CITY OF ALBUQUERQUE

**Re: Twownhouse Project AJR Development Inc, 12,000 Zia Road NE,
Traffic Circulation Layout,
Architect's Stamp dated 4-1-13 (K22-D022D)**

Based upon the information provided in your submittal received 04-02-13, the above referenced plan cannot be approved for Building Permit until the following comments are addressed:

ENGINEER'S SEAL 	ZIA PARK HOMES GRADING AND DRAINAGE PLAN Rio Grande Engineering 1806 CENTRAL AVENUE SUITE 201 ALBUQUERQUE, NM 87106 (505) 872-0999 MAY 2013	DRAWN BY WCMJ DATE 5-07-13 2721-LAYOUT-2-05-13 SHEET # JOB # 2721
---------------------	--	---

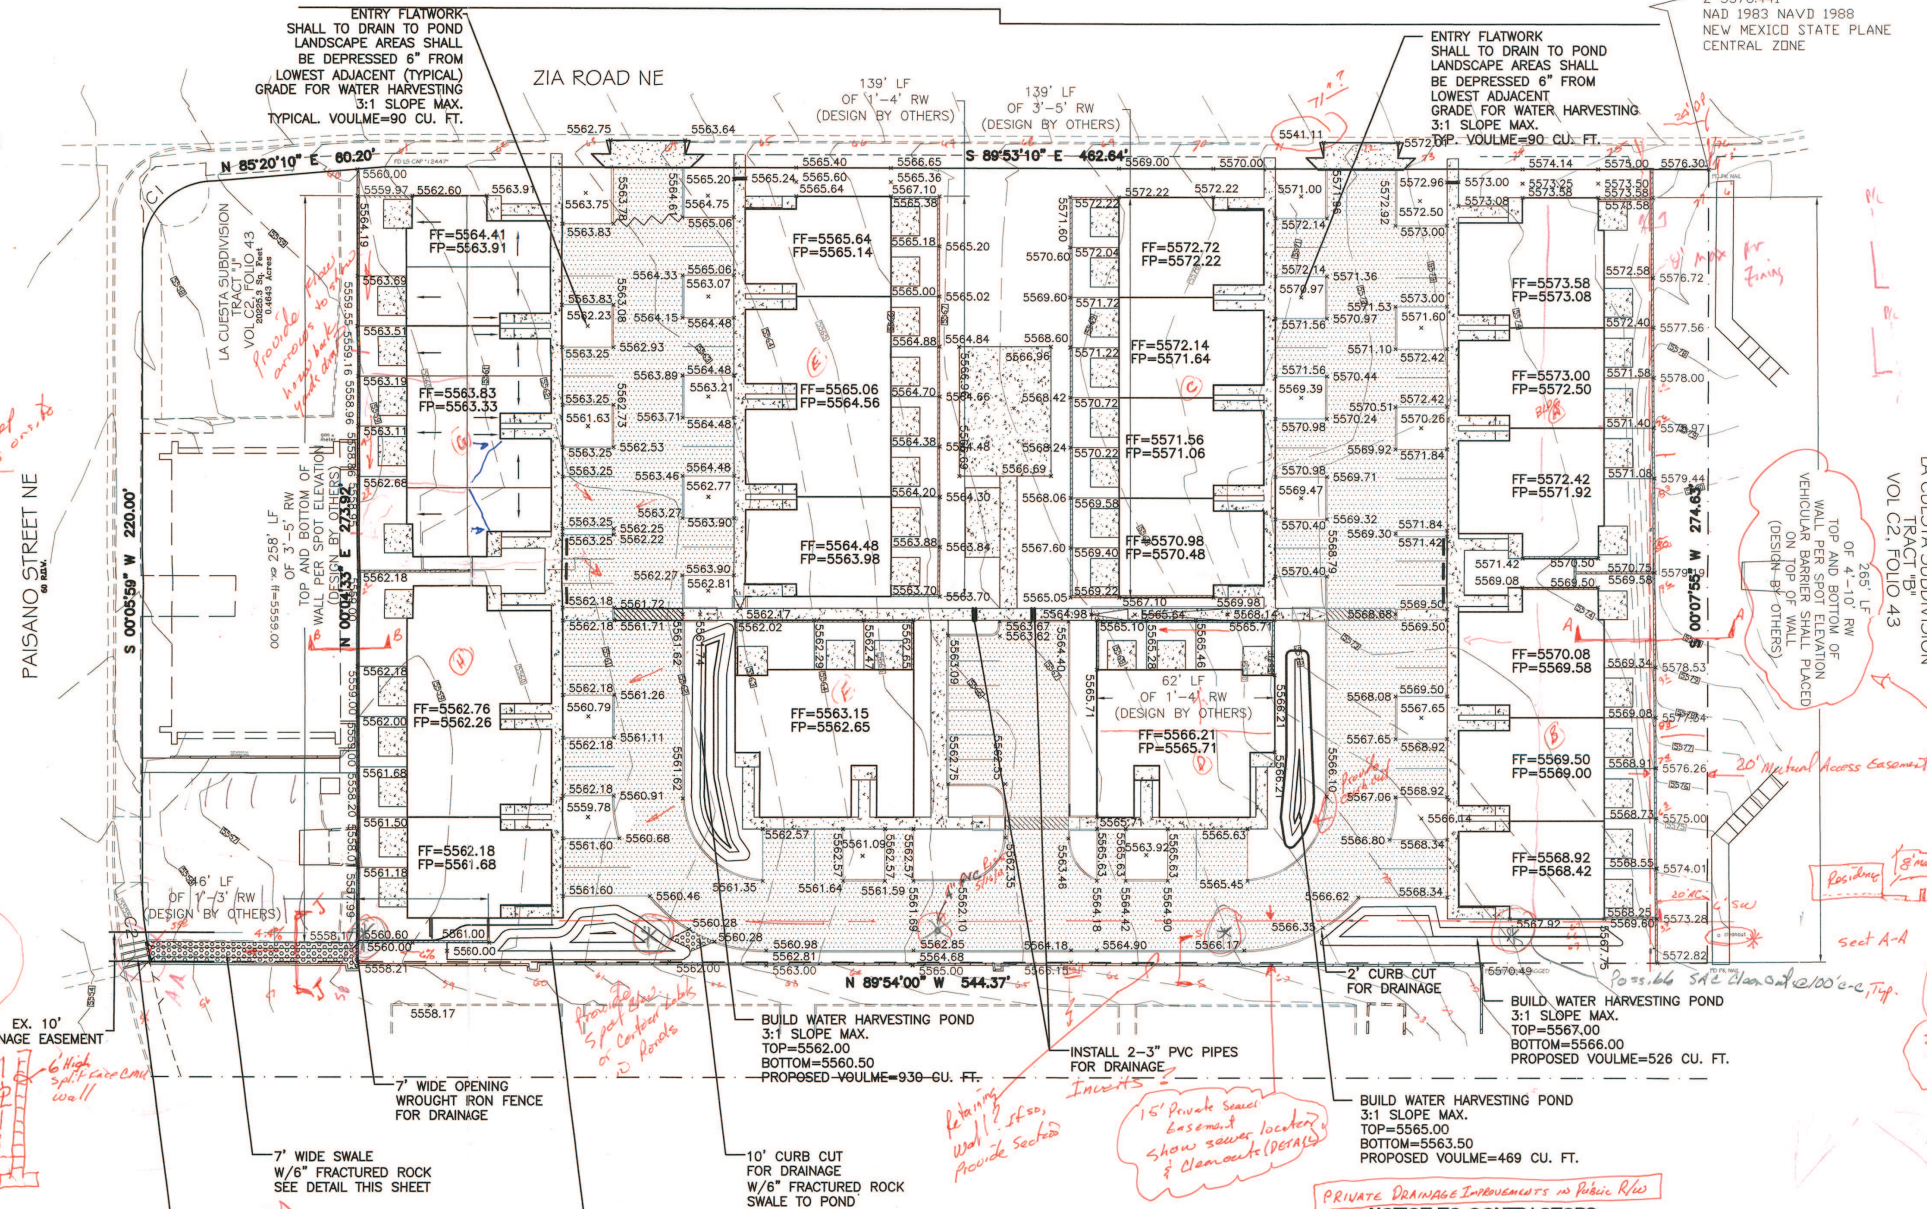
1. All easements and lot lines must be shown.
2. The preliminary plat (DRB 100523) must be approved prior to Building Permit approval.
